APPLICATION CONSULTATION RESPONSE

Application Number:	3/2017/0653
Location:	Land at Chatburn Road Clitheroe BB7 2EQ
Proposal:	Erection of 28 dwellings with associated access, landscaping and open space.

Lead Local Flood Authority (LLFA) Position

DRAINAGE LAYOUT
SCALE: 1:500 @A2
REV -
C116-500 REV A

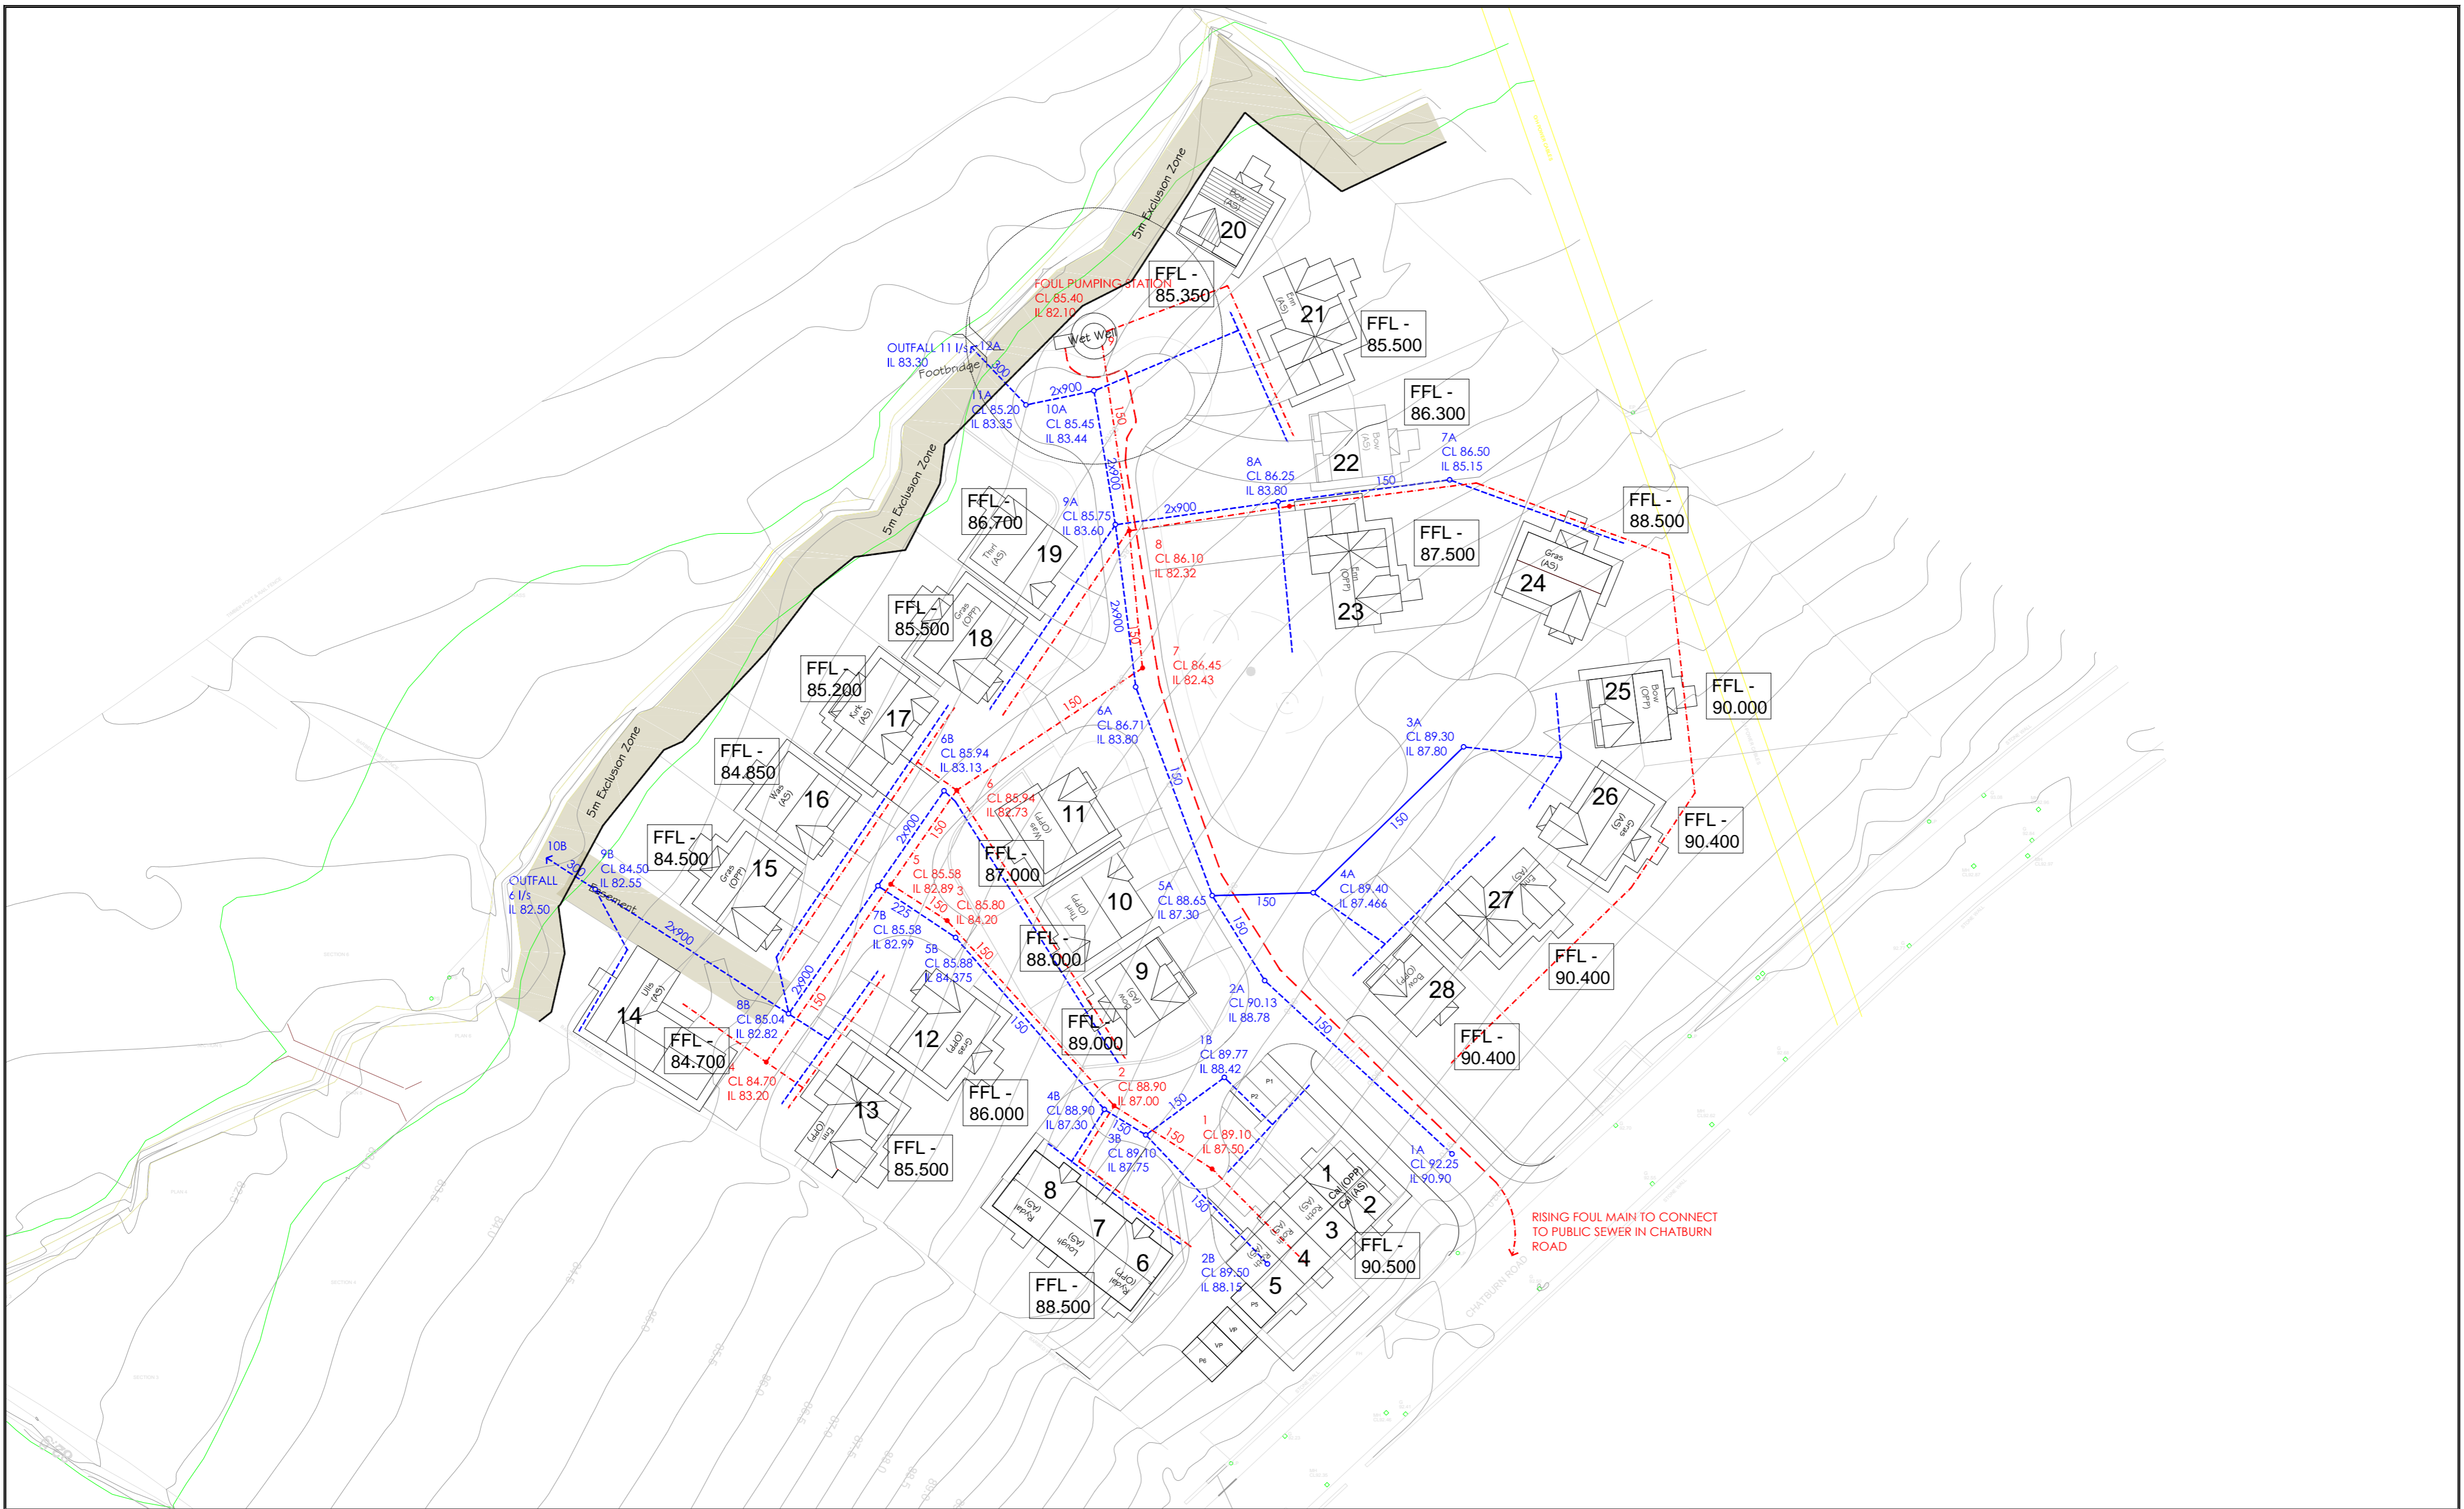
The indicative drainage strategy provided (C116-500 Rev A) indicates that the applicant intends to discharge surface water runoff at a restricted rate of 17l/s. This is based on calculations provided in Figure 8 of the Flood Risk Assessment (Ref P4558). The figures contained within this document are based on a total site area of 2.62ha, all of which is to be positively drained following construction. This information appears to be inaccurate as according to the application form, the total site area is actually only 1.80ha in size. Of this, only a proportion of the site is intended to be positively drained according to the drainage strategy provided. External areas such as private gardens and areas of open space (including the section of the site beyond the watercourse) do not appear to be positively drained.

Owing to these inaccuracies, the applicant has failed to accurately calculate peak greenfield flows and therefore, this is contrary to Standard 2 of the Non-Statutory Technical Standards for Sustainable Drainage Systems. This is sufficient reason in itself for a refusal of planning permission.

The applicant can overcome our objection by submitting revised information that sufficiently addresses the deficiencies identified above. This must be in line with Standard S2 of the Non-Statutory Technical Standards for Sustainable Drainage Systems. Production of a revised FRA will not in itself result in the removal of an objection.
